From: Amanda Scholes on behalf of Planning.Responses
Sent: 14 July 2020 11:32
To: Planning Scanning
Subject: FW: D1833: Sunny Corner, Walberton WA/32/20/DOC D1833
Attachments: D1833-007F Construction Details Sheet 3 of 3.pdf; D1833-010B Pond Cross Sections.pdf; D1833-002E Engineering Layout - Below Ground Drainage.pdf; D1833 SW Design 1.2.pdf; D1833 Drainage Maintenance Schedule & Phasing Plan v3.pdf; D1833-001 Engineering Layout - Levels, Contours.pdf; D1833-300 Impermeable Areas Comparison.pdf

From: Laura Gibbons [REDACTED]
Sent: 14 July 2020 10:59
To: Planning.Responses <Planning.Responses@arun.gov.uk>
Cc: Andrew Wood <Andrew.Wood@arun.gov.uk>; Dan Lytton [REDACTED]
Subject: Fwd: D1833: Sunny Corner, Walberton WA/32/20/DOC D1833

The revised information is adequate to address our concerns and condition 8 can be discharged. Please ensure that the following plans are listed on any approval:

From: Laura Gibbons [REDACTED]
Sent: 23 June 2020 09:20
To: Dan Lytton [REDACTED]
Cc: Mark Akmenkalns [REDACTED] Jason Osborn [REDACTED]
Subject: Re: D1833: Sunny Corner, Walberton WA/32/20/DOC D1833

SECTION 1 - LONGSECTION
SCALE: H 1:200,V 1:100. DATUM: 15.000

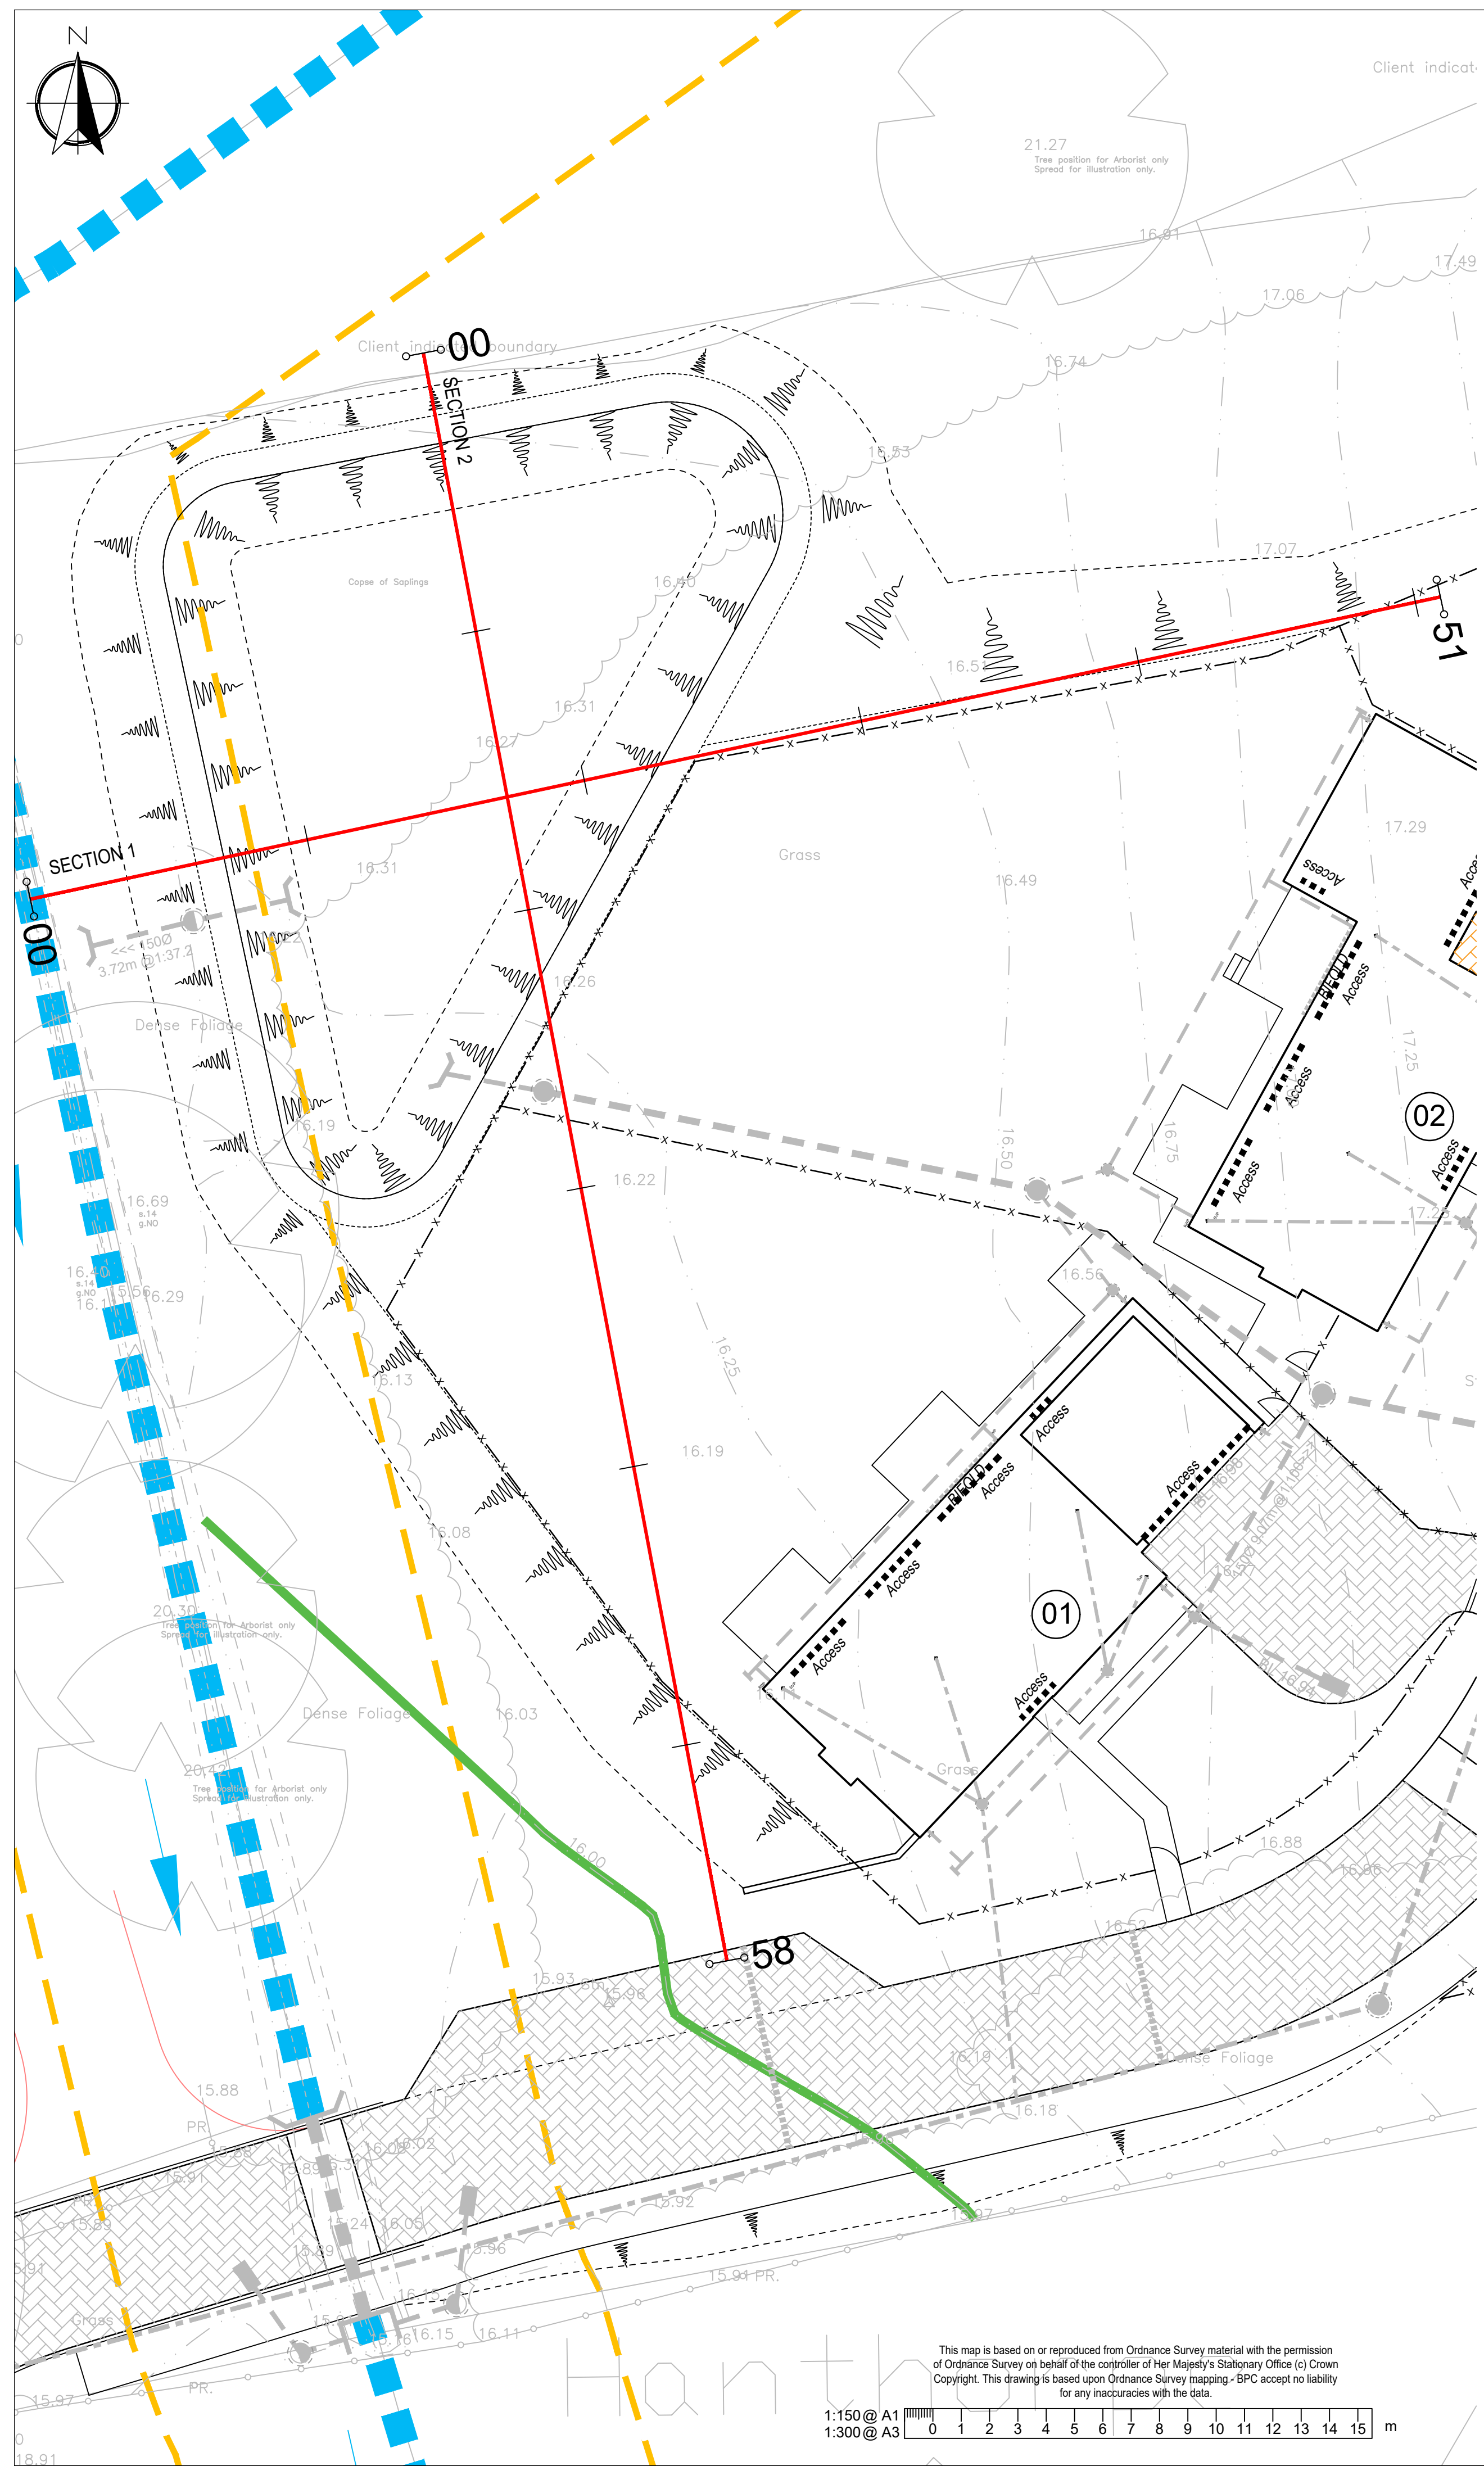
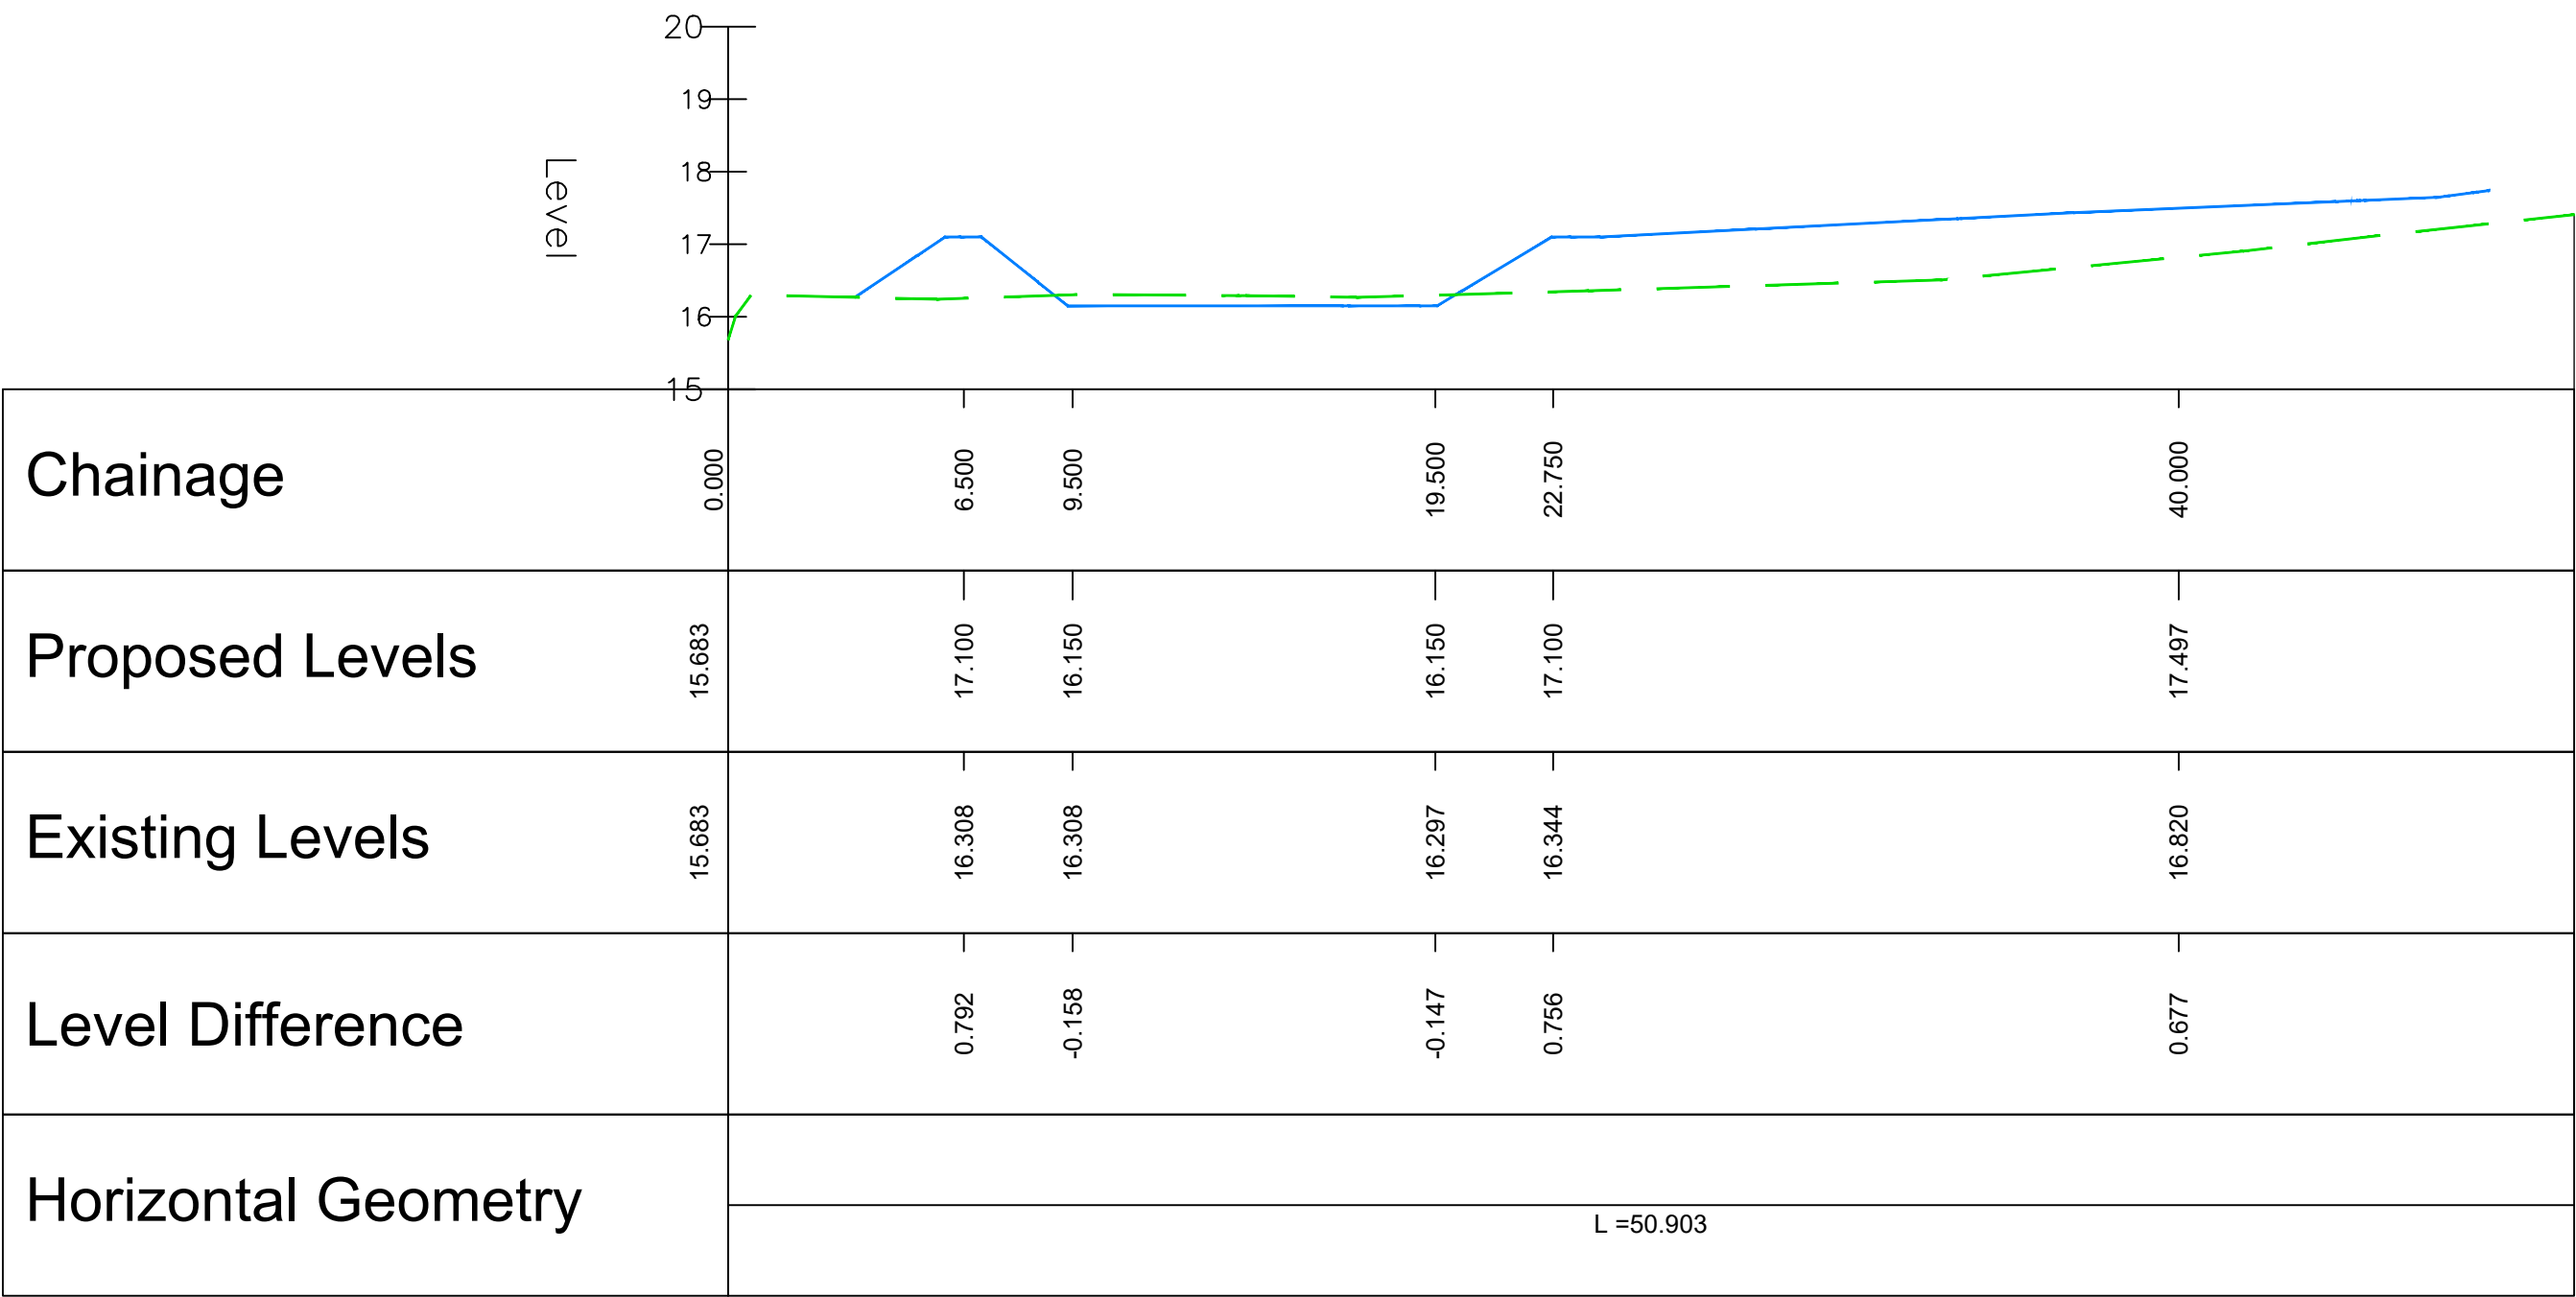
Please ensure that top of bank levels, and base levels of pond are picked up on each cross section. Existing and proposed levels are labelled as being consistent, despite profiles showing change.

9. Done, see updated drawing 010
10. N/A
11. N/A
12. N/A
13. N/A
14. N/A
15. N/A
16. I have included this explicitly within the revised maintenance schedule
17. N/A
